Consultation response

LU/343/20/L

Listed building consent for the conversion of existing dairy building into a new kitchen, internal alterations, a replacement carport and replacement garden fencing

Vine Cottage 1 Church Street Littlehampton BN17 5EL

GROUND FLOOR PLAN
AS PROPOSED

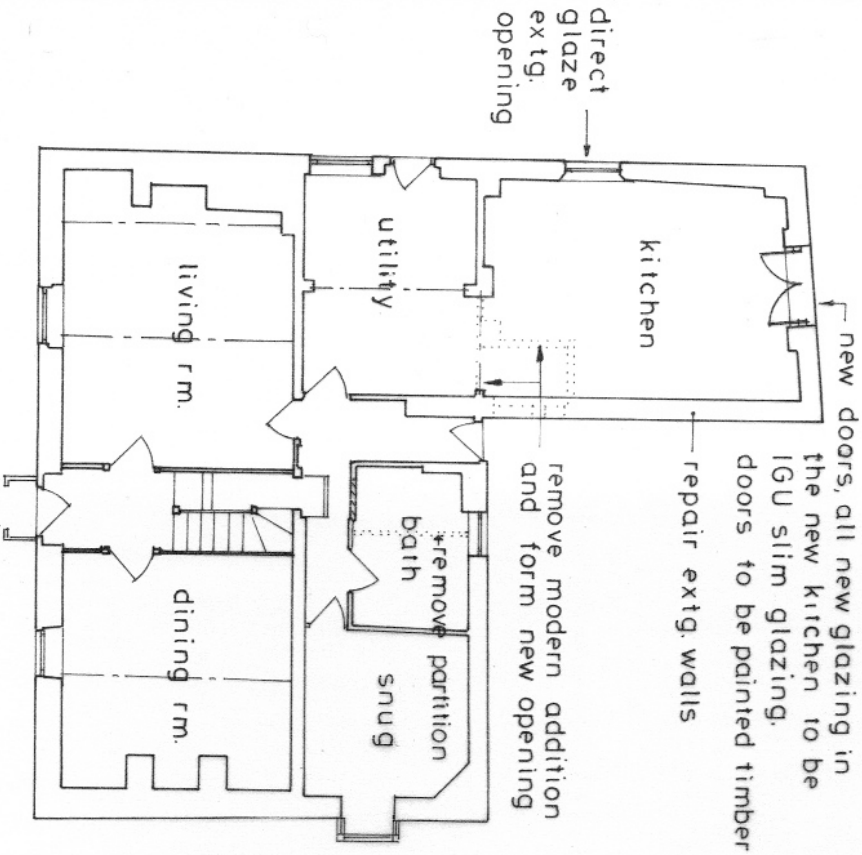
The design of the space is reflective of the main listed building and the materials appear to be carefully considered. Whilst I note that there are references to the fact that the flint/chalk walling (both new and repairs) will match existing, it might help to have a sample panel provided so that we can be sure of the quality of the final walling. I note that the intention is to include two openings with the slimmer double glazing and think that this is acceptable as it only relates to new joinery.

The internal works relate to the removal of a modern wall in the existing ground floor bathroom and the creation of an opening to provide access to the newly created space (in the former dairy). Materials salvaged as part of the creation of the opening will be re-used on the site. Both elements are acceptable.

replacement oak car-port, with natural slate roof

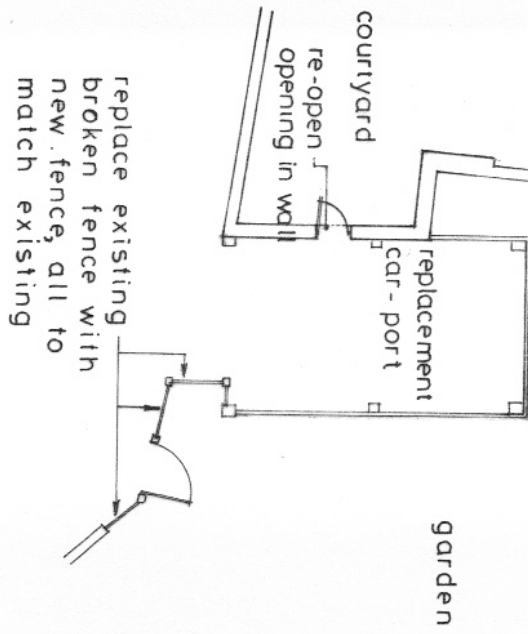
The existing carport is in a poor state of repair and is of no significance to the listed building. Its replacement with a structure which is more in keeping with both the listed building and conservation area is supported. Like the replacement fencing will not cause harm.
